CITY OF ALBUQUERQUE

**RE: The Varela Residence Volcano Cliffs Unit 18
6505 Pato Rd NW, S.A.D. 228, Lot 21 Block 6
Grading and Drainage Plan
Engineers Stamp Date 12/27/16 (D10D003M21)**

C-1.0

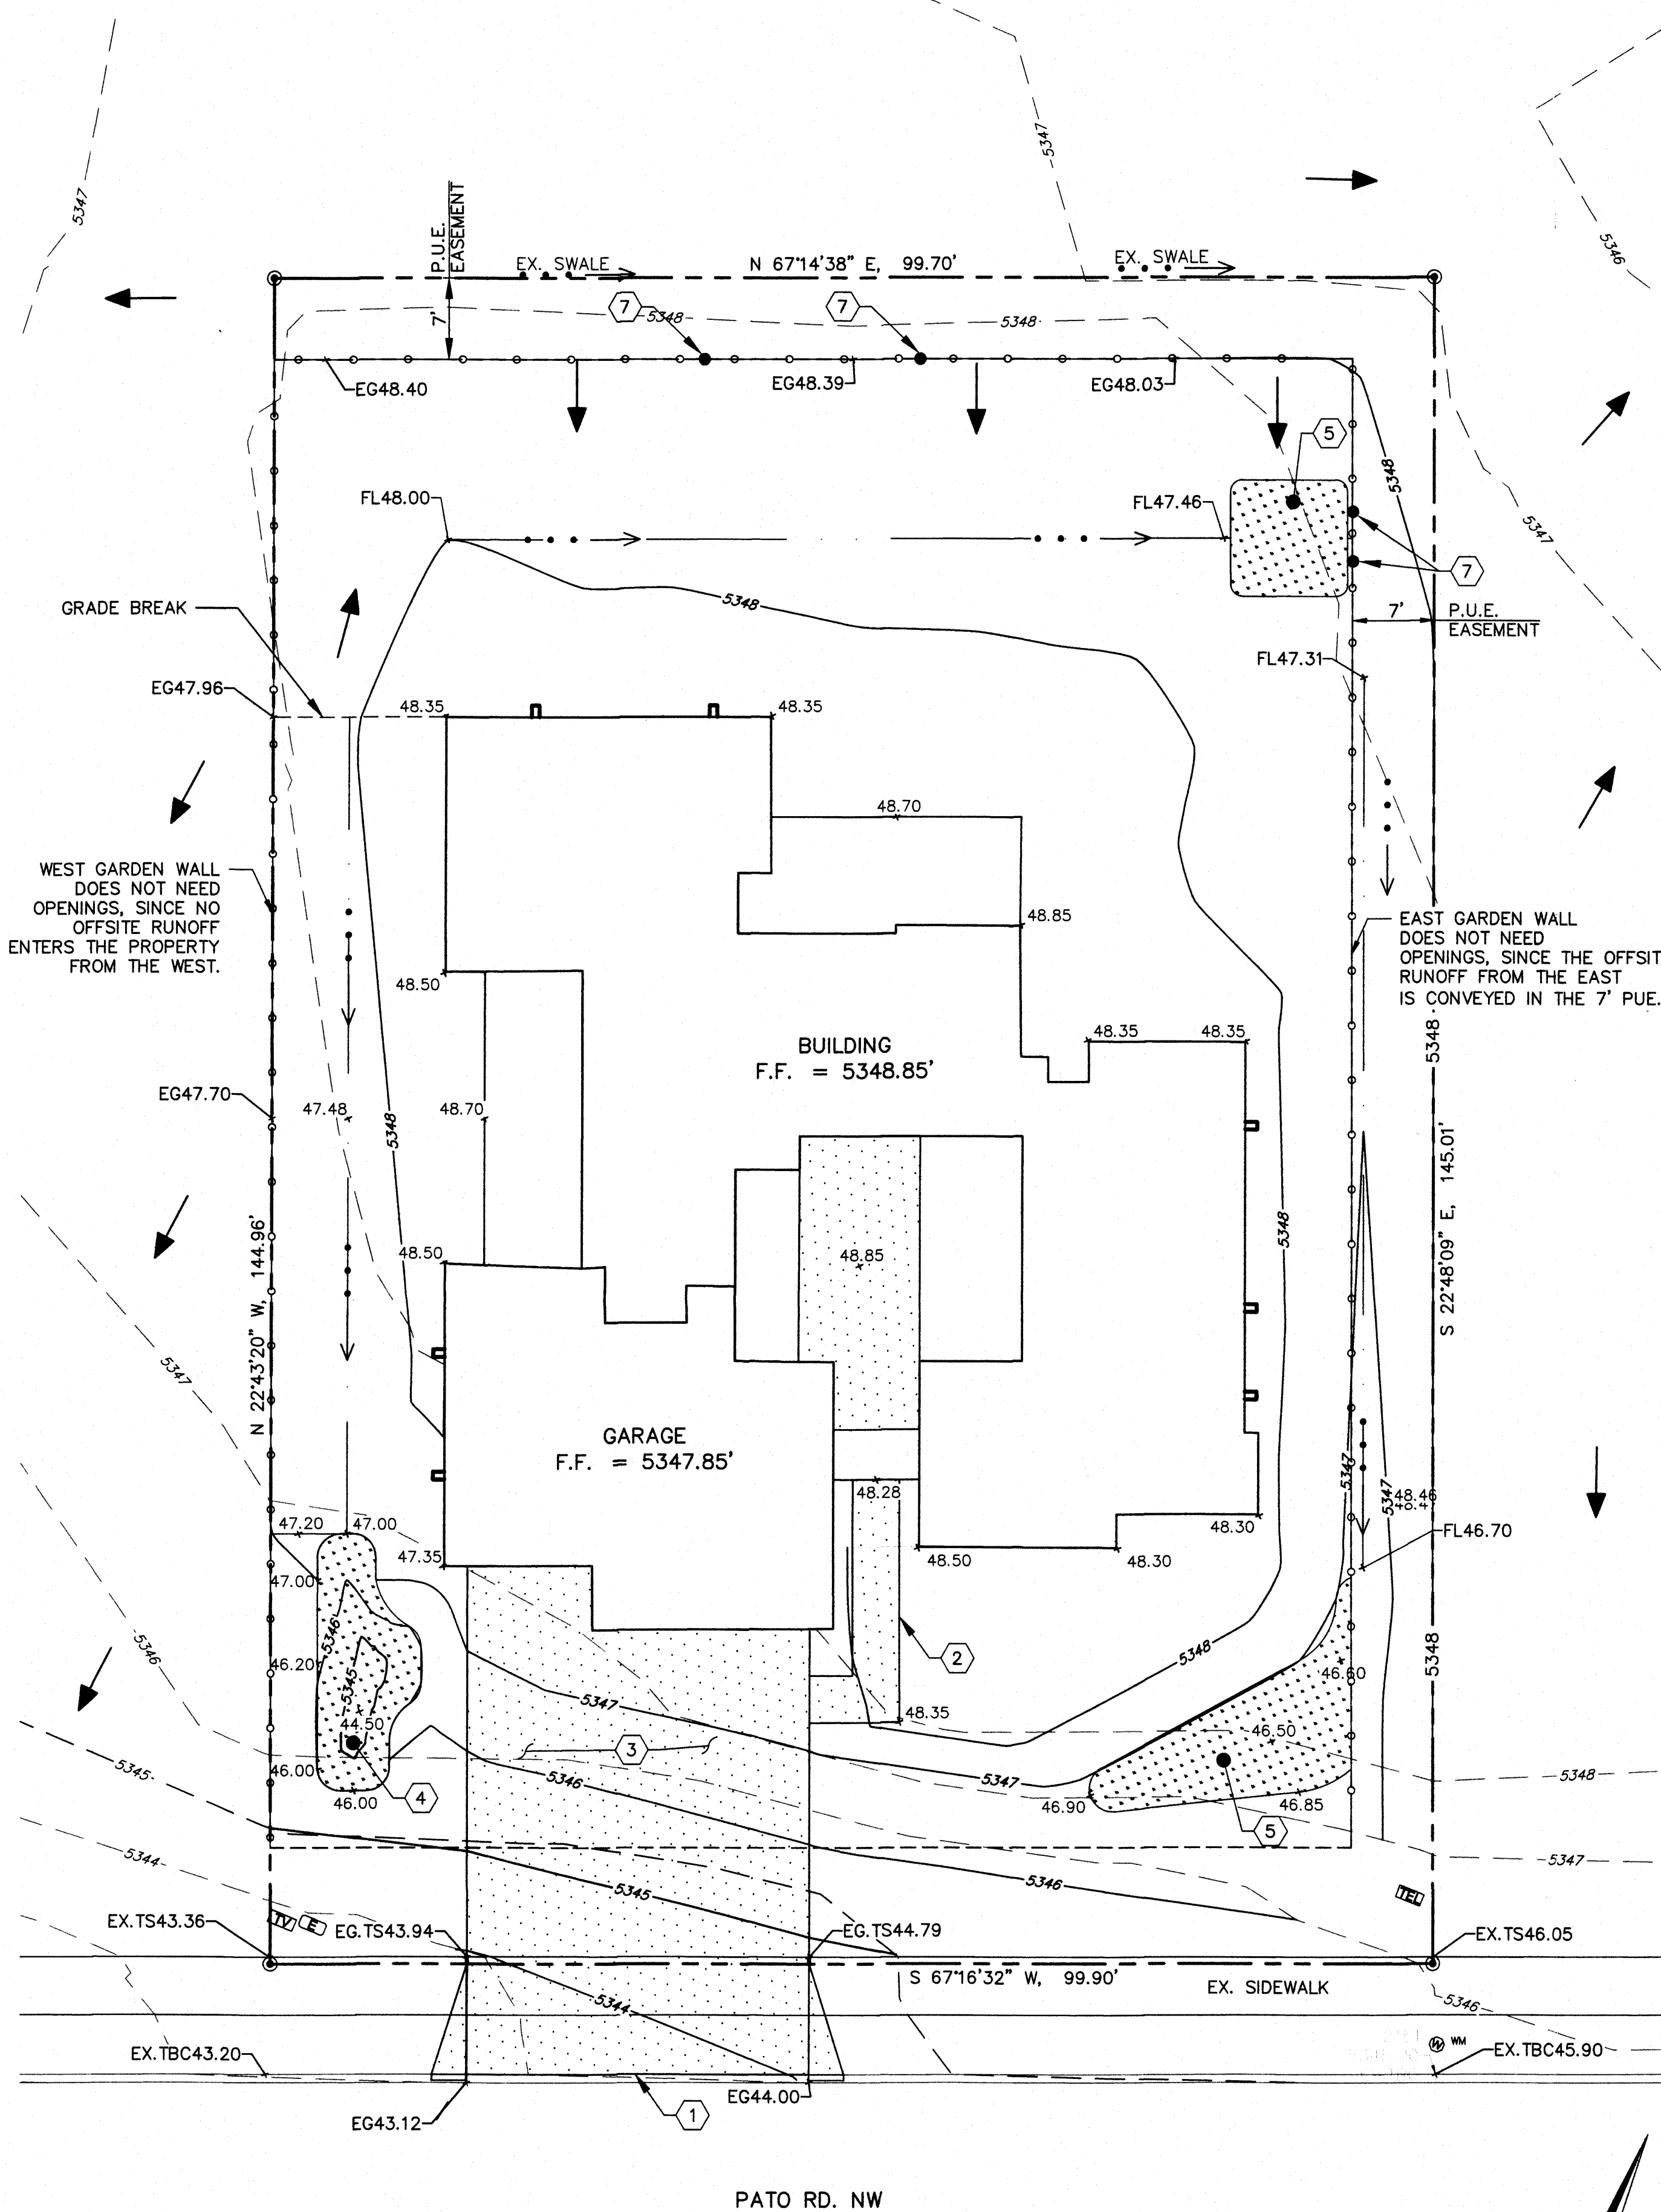
- Provide a statement requiring that a pad certification or a written statement by you is required before the home is released for building permit or the concrete pad is poured.
- Provide a statement informing the owner/contractor that a separate for a garden wall or retaining wall is required, and an opening 3" above grade is required for flows to pass through their rear yard according to the S.A.D. 228 master plan.
